Development Review Board Comments

**Project Number:** 1004176  
**Application Number:** 05DRB-00782

Tract 2, Lands of Manuel G. Jaramillo

RE: Tract 2, Lands of Manuel G. Jaramillo/sketch

RETRACEMENT SURVEY PLAT

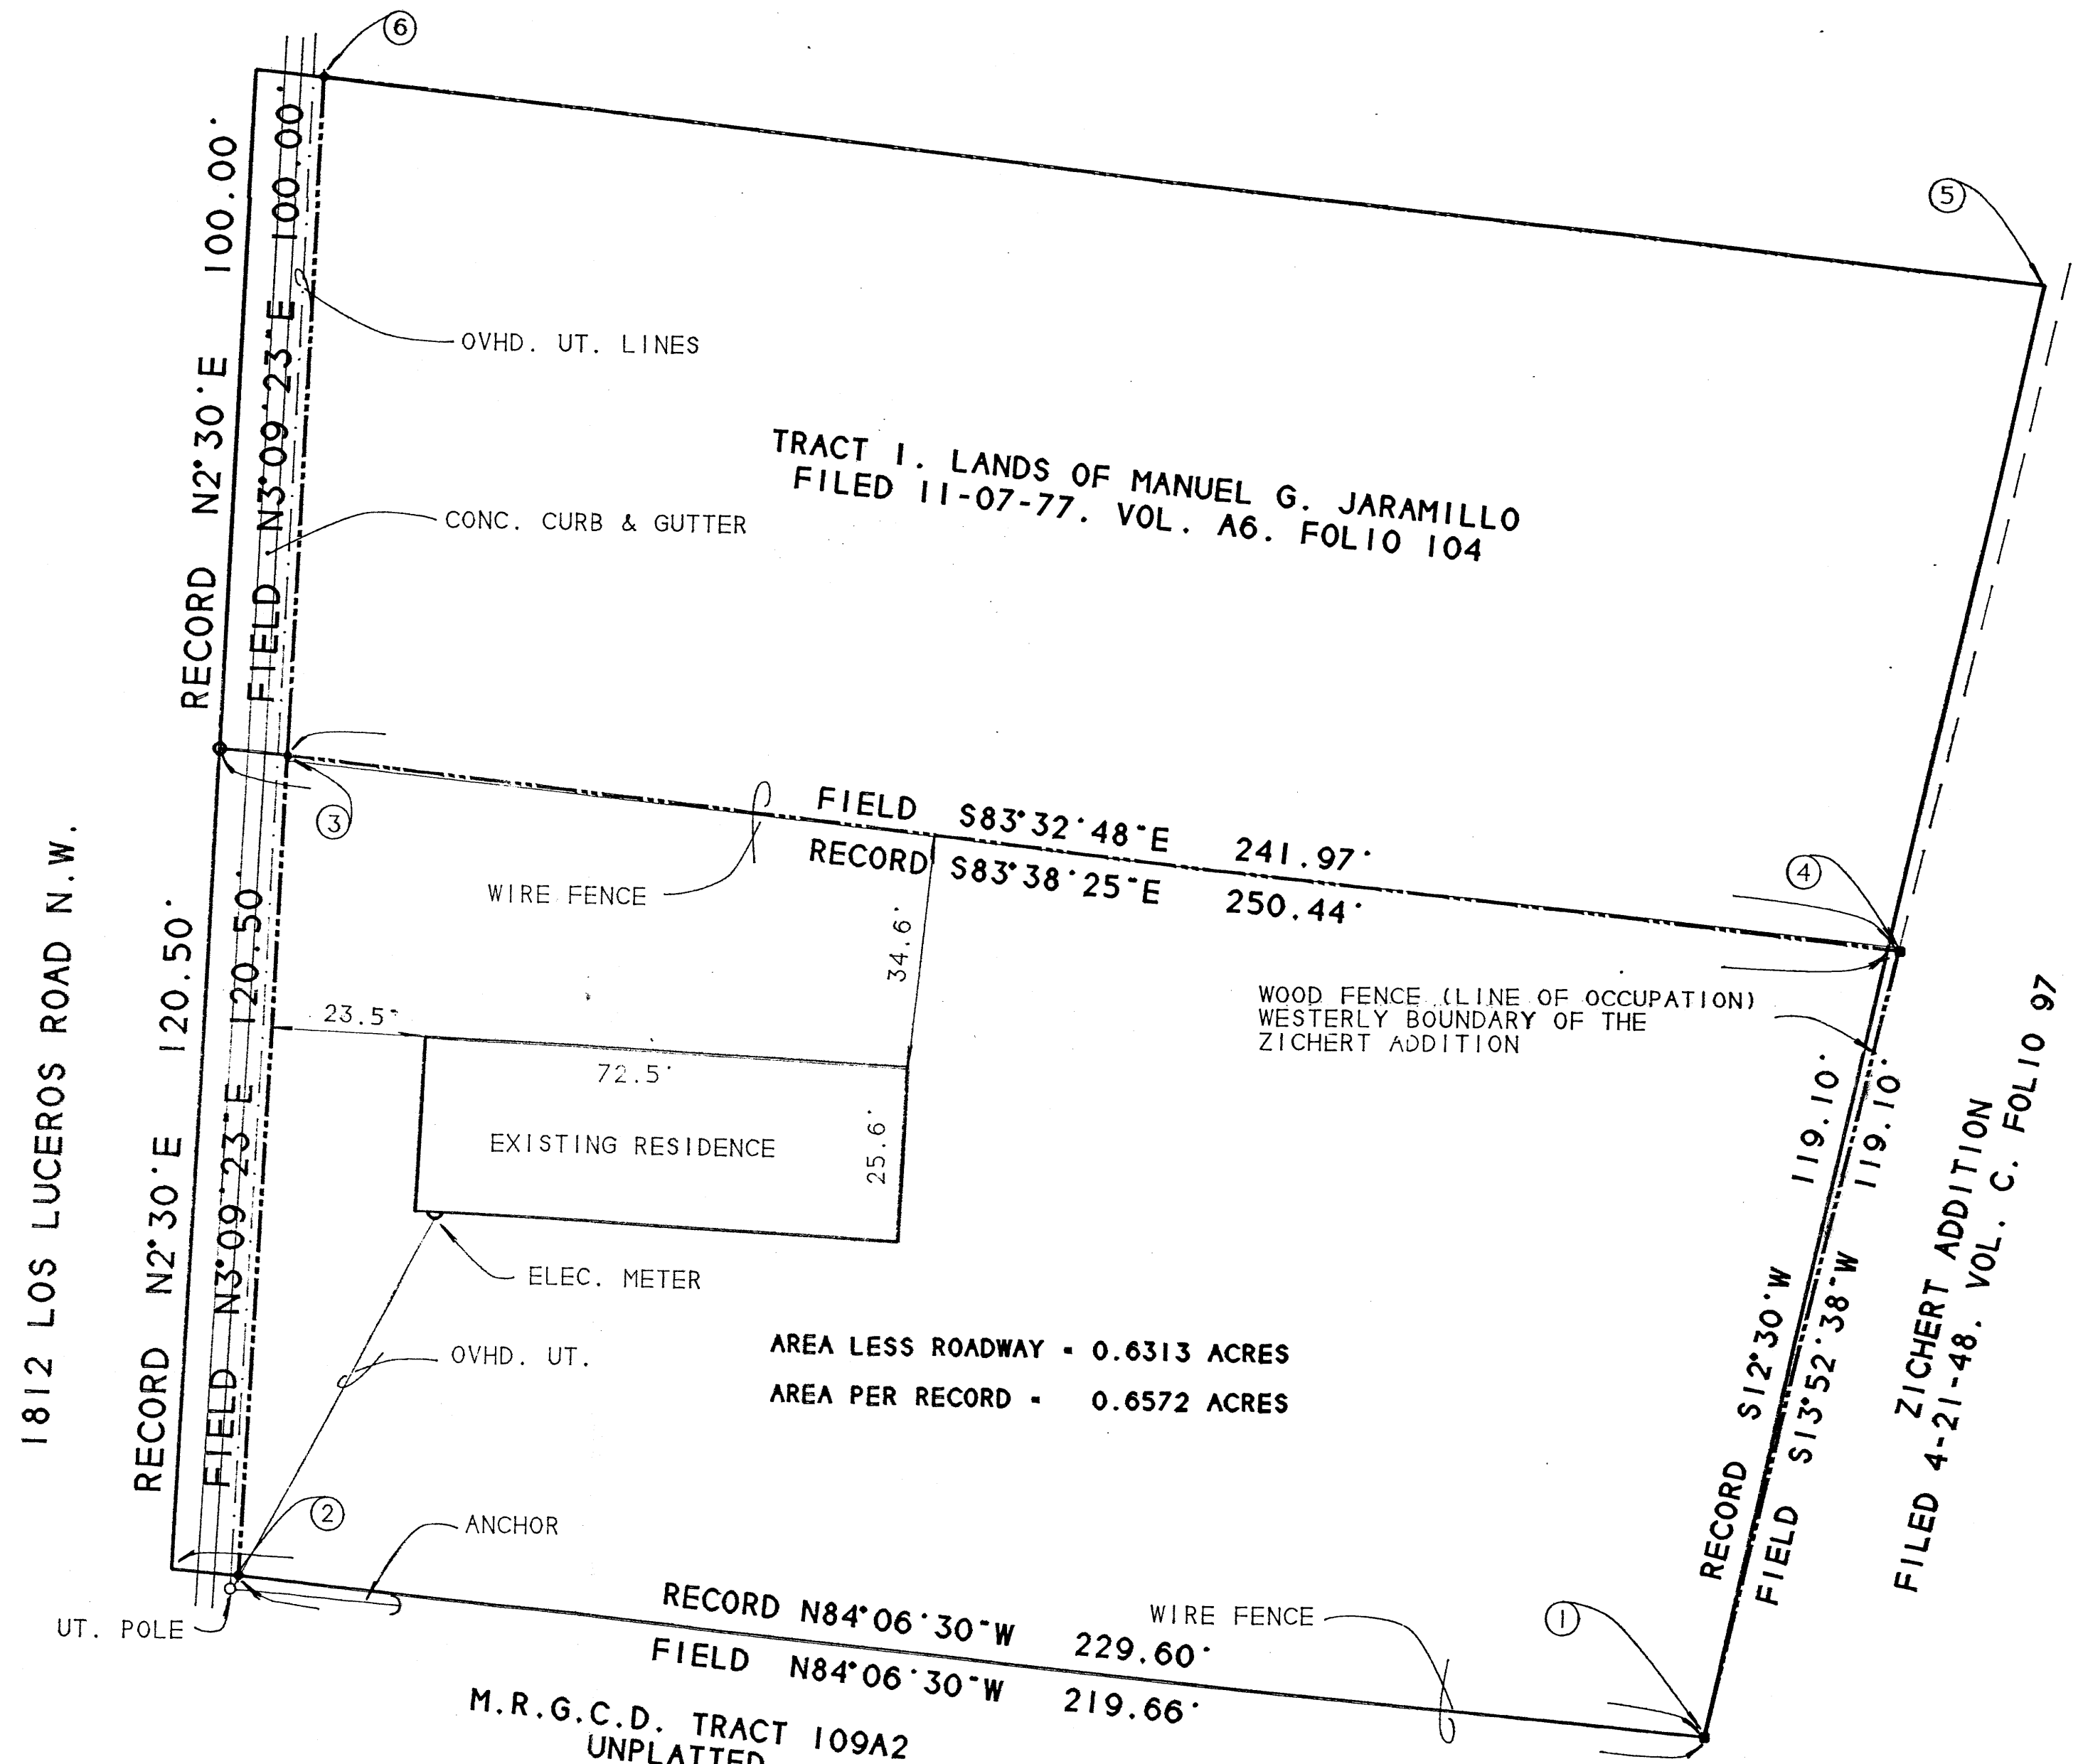
<u>No.</u>	<u>Comment</u>
1)	Unclear as to how the lot is being split? Do the two new lots have direct access to Los Luceros Road?
2)	Need to provide a cross-section of Los Luceros showing the right-of-way width, pavement width, location of curb and gutter and sidewalk.
3)	Infrastructure may be required.

Where will the new lot lines be? Comments will be provided at the meeting.

As long as the lot sizes are at least 75' minimum width and 10,890 square feet each, subdivision is possible.
